KITTITAS COUNTY

MEMORANDUM

TO: All Staff
FROM: Public Works Plan Review Team
DATE: August 9, 2022
SUBJECT: LP-22-0003 Haybrook Farms Ph3

HAYBROOK FARMS PHASE 3
PART OF SECTION 30, T. 18 N., R. 19 E., W.M.
KITITAS COUNTY, WASHINGTON
- PRELIMINARY PLAT -

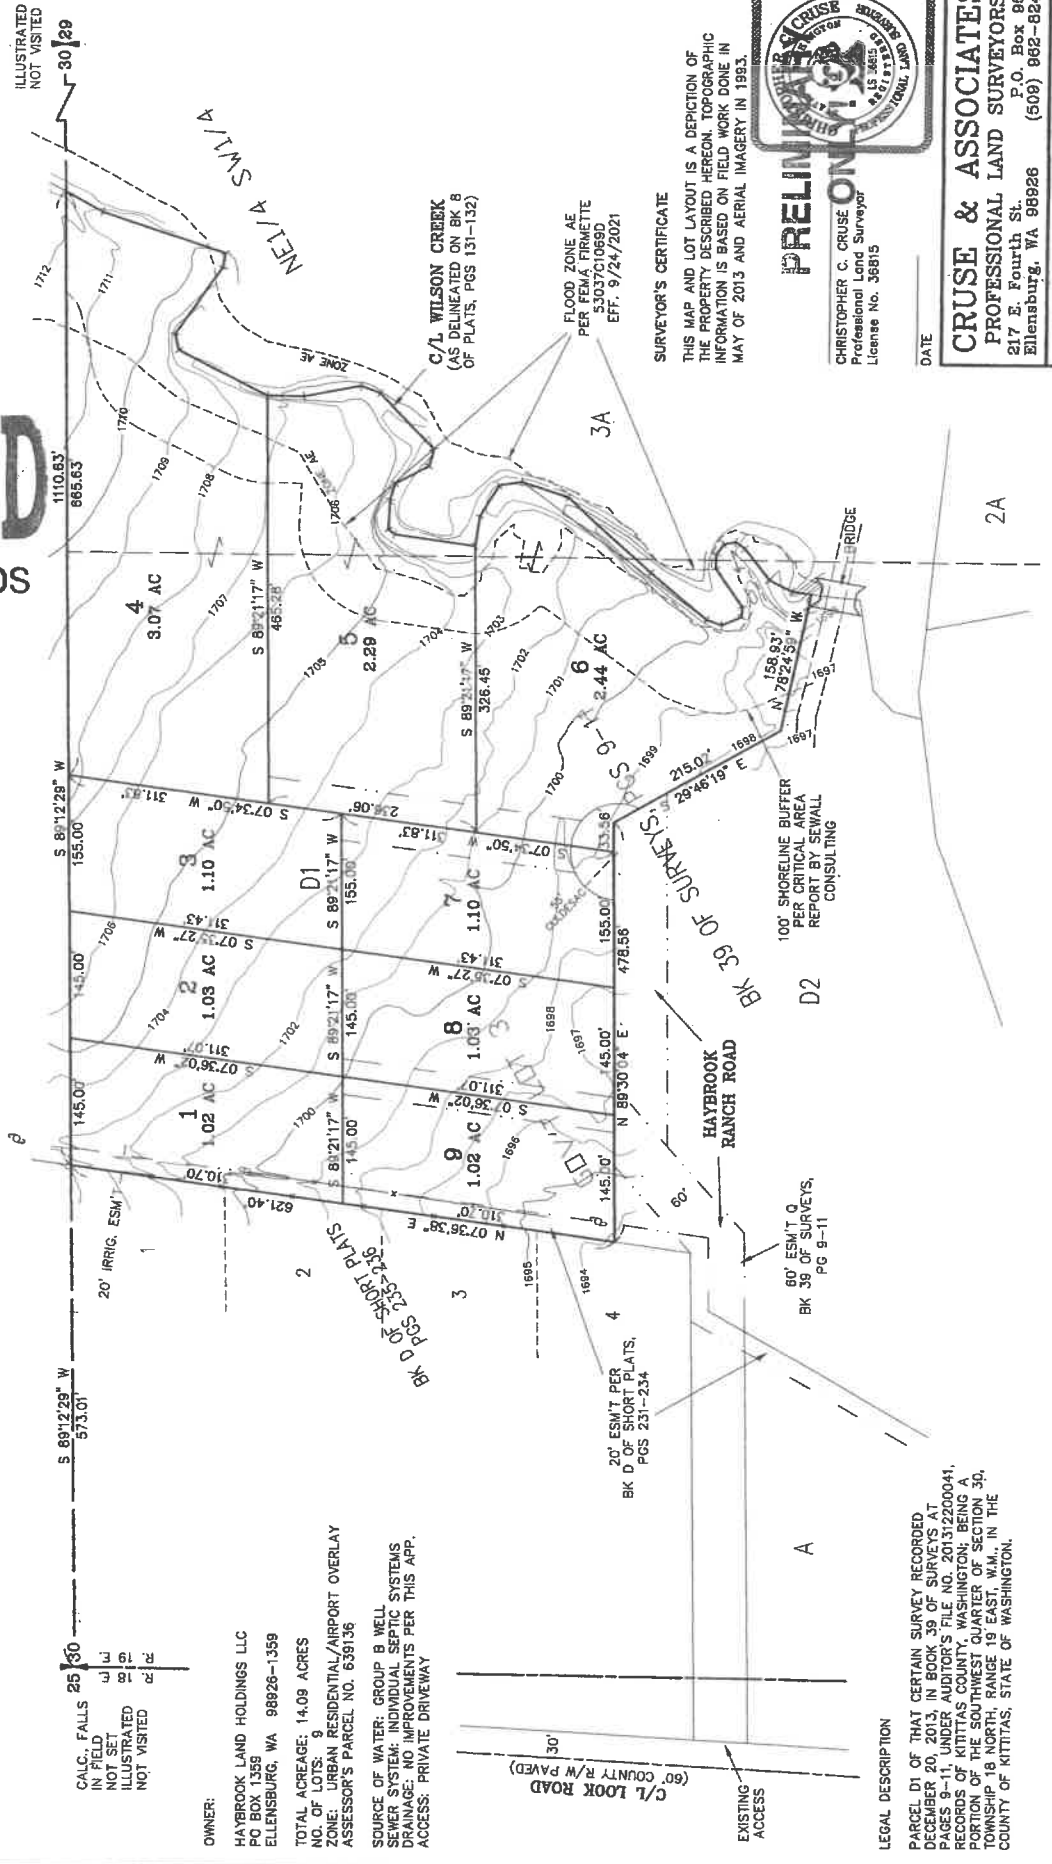
<p>SURVEY</p>	<ol style="list-style-type: none"> 1. Submitted application does not meet the requirements of WAC:332-130-145 in regards to vertical datum, basis of bearing, benchmarks used, source of contours, etcetera. 2. There is no Engineer of Record on the face of the Prelim Plat. <p>Prior to approval of the Final Plat, the following issues will need to be addressed:</p> <ol style="list-style-type: none"> 1. The legal description is not coincident with the title report. 2. Controlling corners will need to be noted, and property corners set. 3. The boundaries along Wilson Creek will need to be delineated. 4. The access easements will need to be labelled, and the new access easement outside the plat boundaries will need to be dedicated via separate easement. 5. Lot closures will need to be submitted.
<p>FLOOD</p>	<p>The applicant has correctly noted that a portion of lots 4, 5, and 6 of the proposed plat would be located in the 100-year floodplain.</p> <p>Per KCC 14.08.220, all subdivisions as well as new development shall:</p> <ol style="list-style-type: none"> 1. Be consistent with the need to minimize flood damage. 2. Have public utilities and facilities such as sewer, gas, electrical, and water systems located and constructed to minimize flood damage. 3. Have adequate drainage provided to reduce exposure to flood damage. 4. Where base flood elevation data has not been provided or is not available from another authoritative source, it shall be generated for subdivision proposals and other proposed developments containing greater than 50 lots or 5 acres (whichever is lesser) and shall be included as part of the application and shall be noted on the final mylar. 5. All subdivisions shall show on the face of both the preliminary and final plat, for either short or long plats, the boundary of the 100-year floodplain and floodway.
